15 July 2021

File No: 2021/315838
Our Ref: R/2019/26/B

Response to Submissions – Atlassian Office and Hostel Development – SSD 10405

DRAWING
SHED - SOUTHERN
ELEVATION
DOCUMENT NUMBER
DA-11C-GXX-02
ISSUE
6

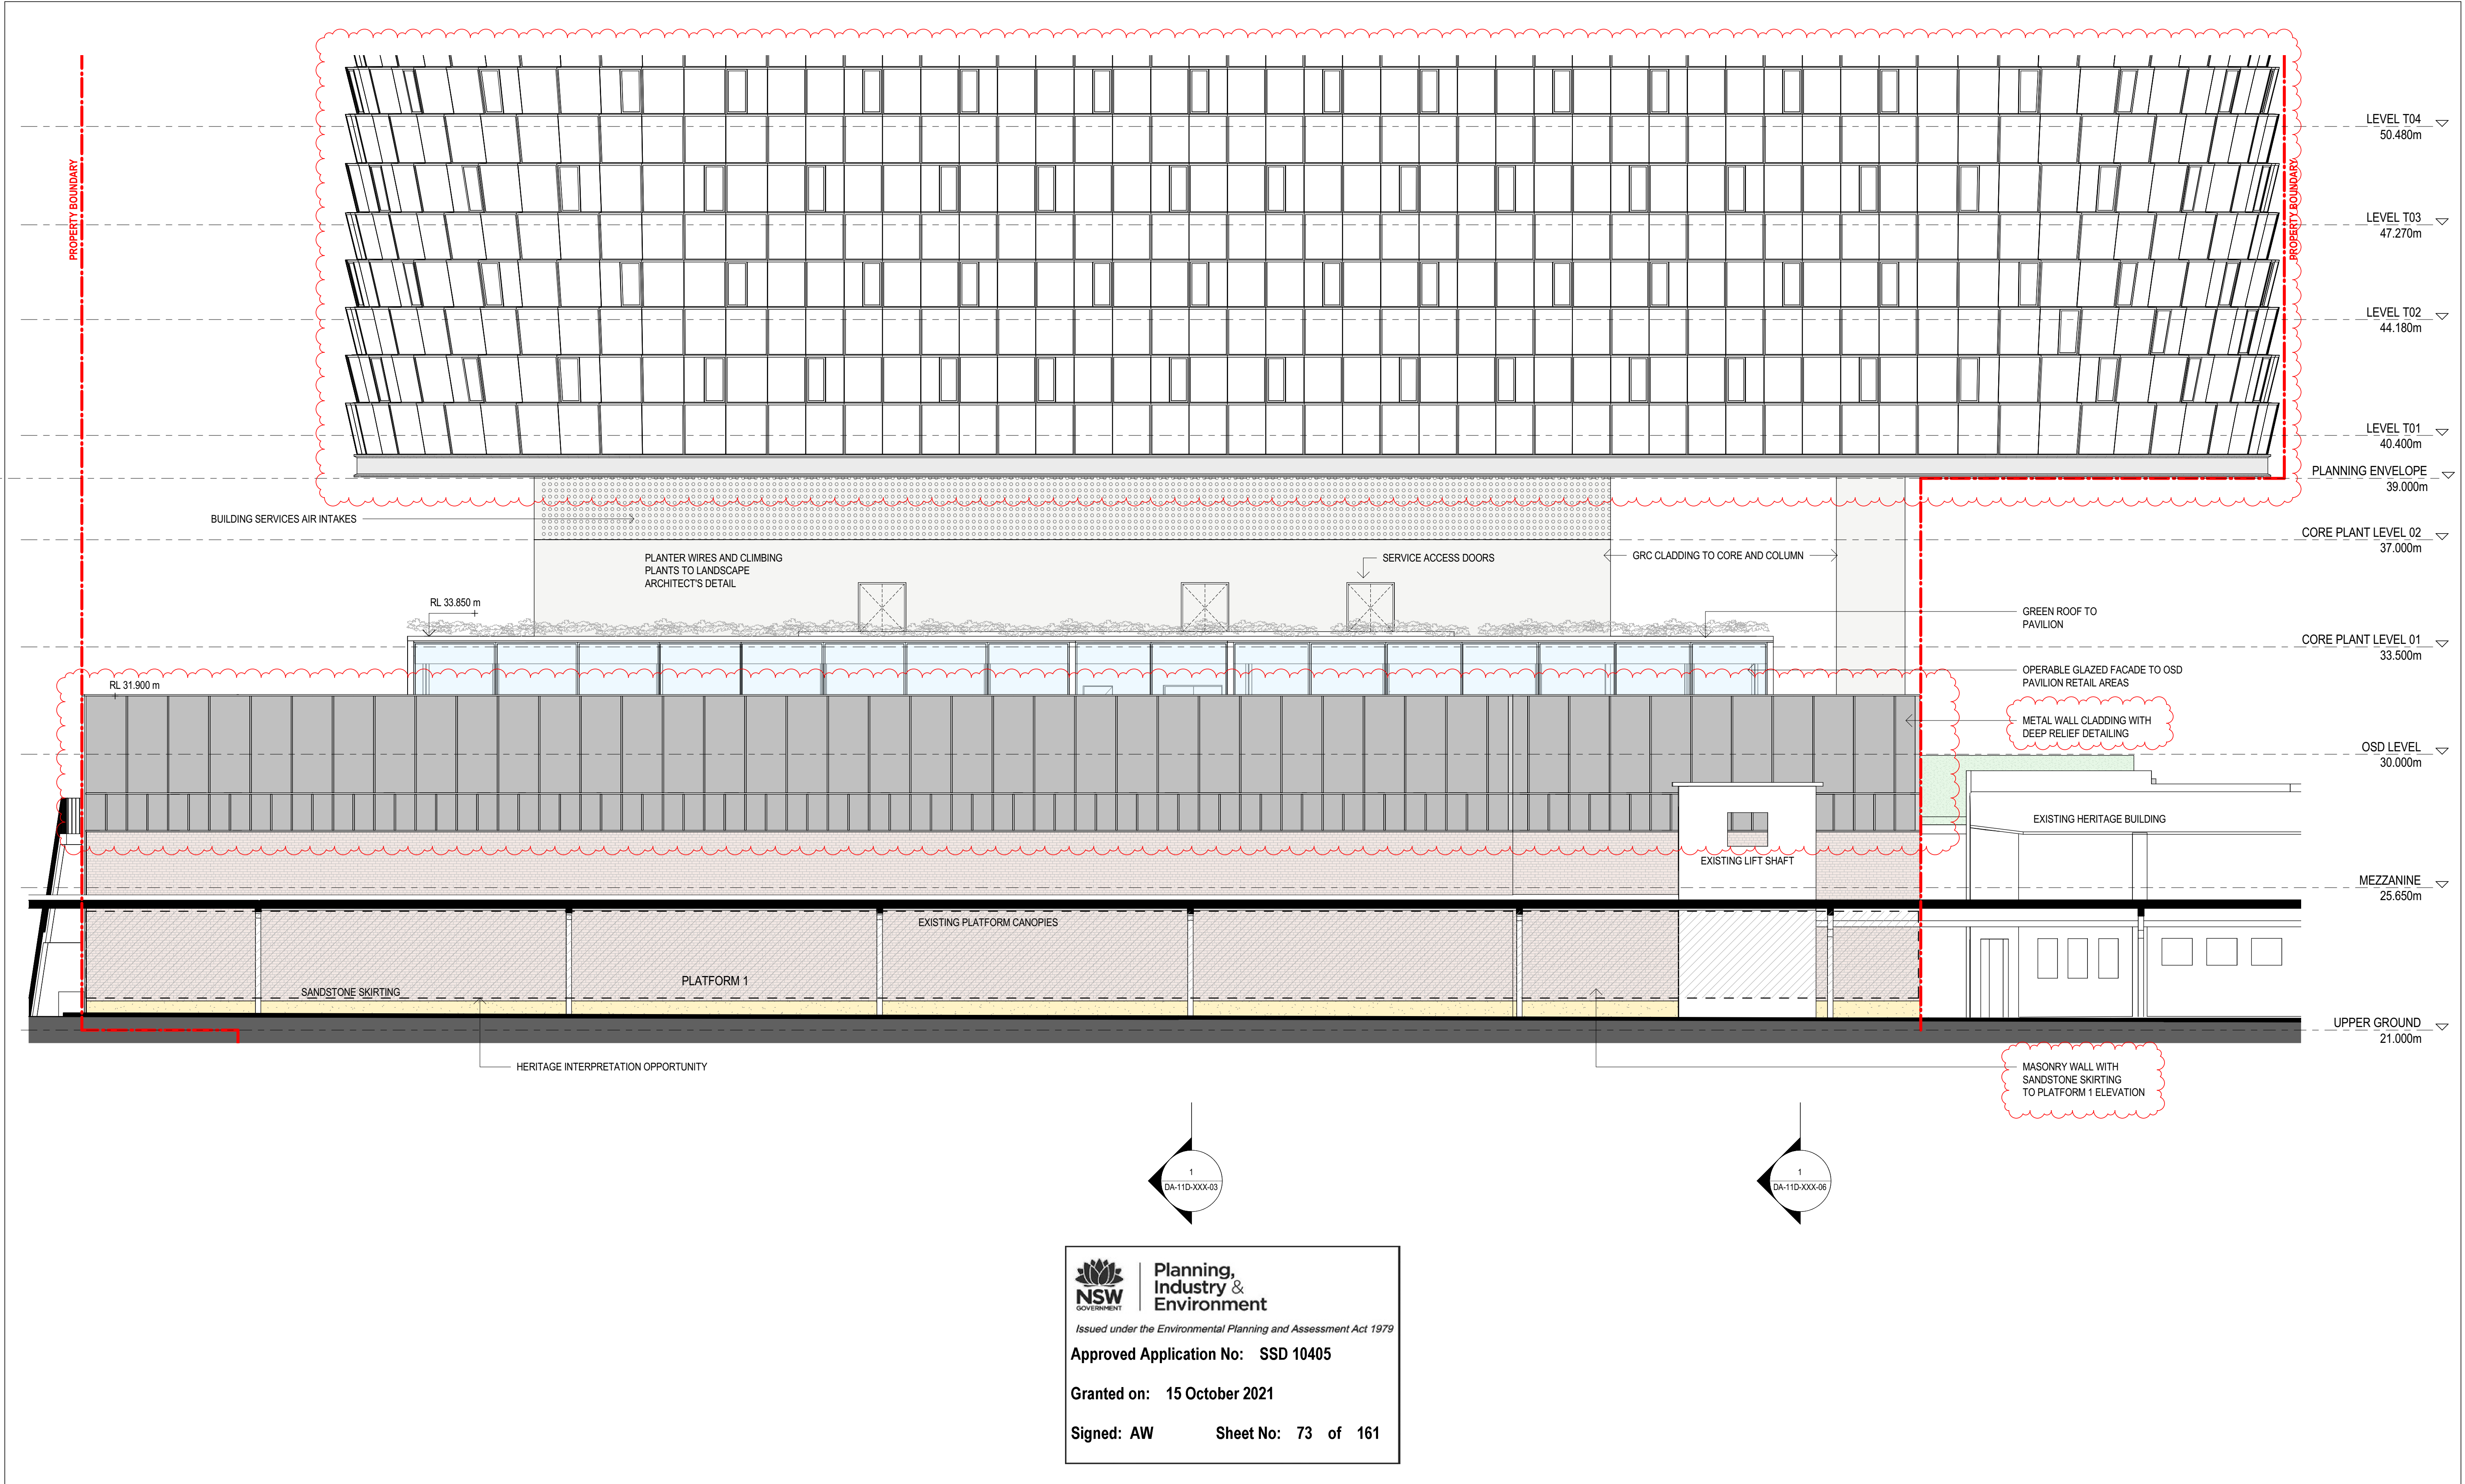
2. While City staff remain concerned with the extent of demolition proposed, the reincorporation and interpretation of significant fabric is supportable. Conditions of consent regarding any Heritage Interpretation Strategy should require consultation with the City.
3. The bleachers continue to have an unacceptable impact on what will remain of the former Inward Parcels Shed as follows:
 - a. The bleachers and pavilion obscure most of the original roof form, reducing the legibility of the item. The realignment of the stairs on the southern elevation exacerbates this issue.

DRAWING
SHEP - EASTERN ELEVATION
DOCUMENT NUMBER
DA-11C-GXX-03
ISSUE
6

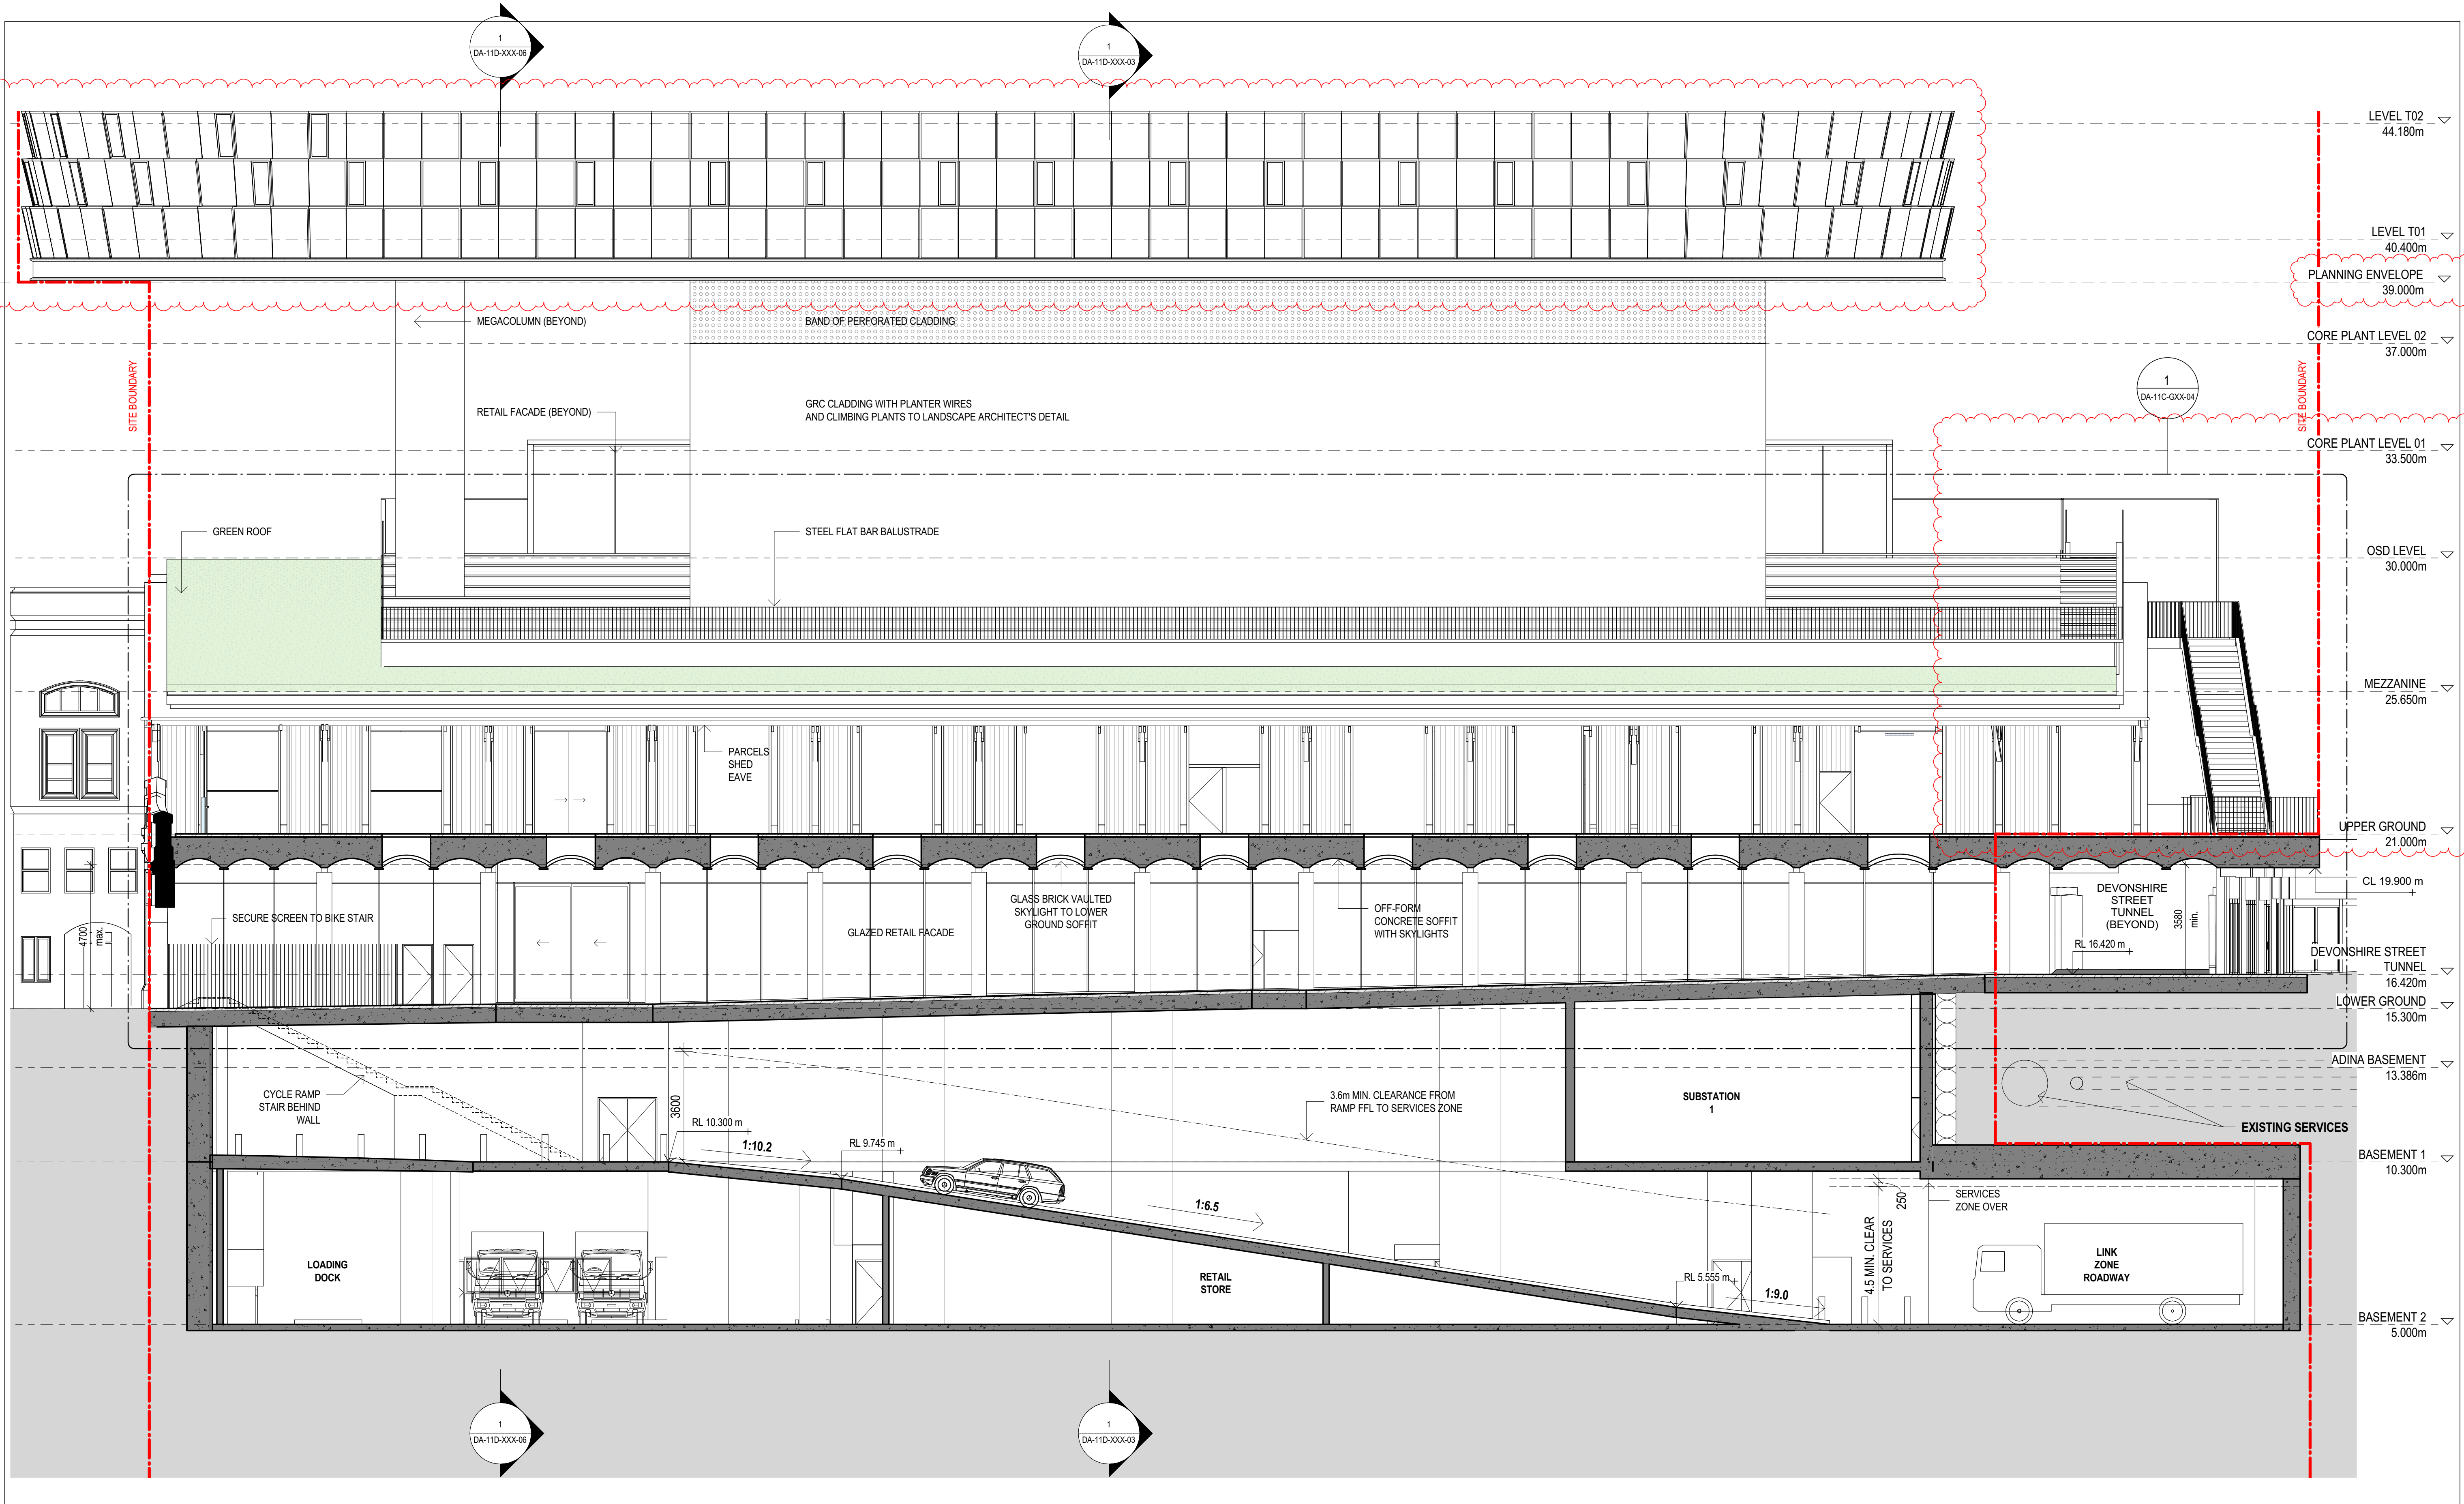
- 4. While the City does not object to the reduced separation between the Shed and tower above, the pavilion structure continues to add unnecessary bulk and thereby undermine the void between the Shed and the soffit.
- 5. City staff acknowledge the changes made to the eastern wall adjoining Platform 1, however, this continues to be a missed opportunity to incorporate artwork or heritage interpretation as previously suggested. The proposal should be drafted prior to determination and finalised prior to the issue of any Construction Certificate.
- 6. City staff raise no objections to the form and materiality of the northern elevation of the Shed, particularly the use of reeded glass.
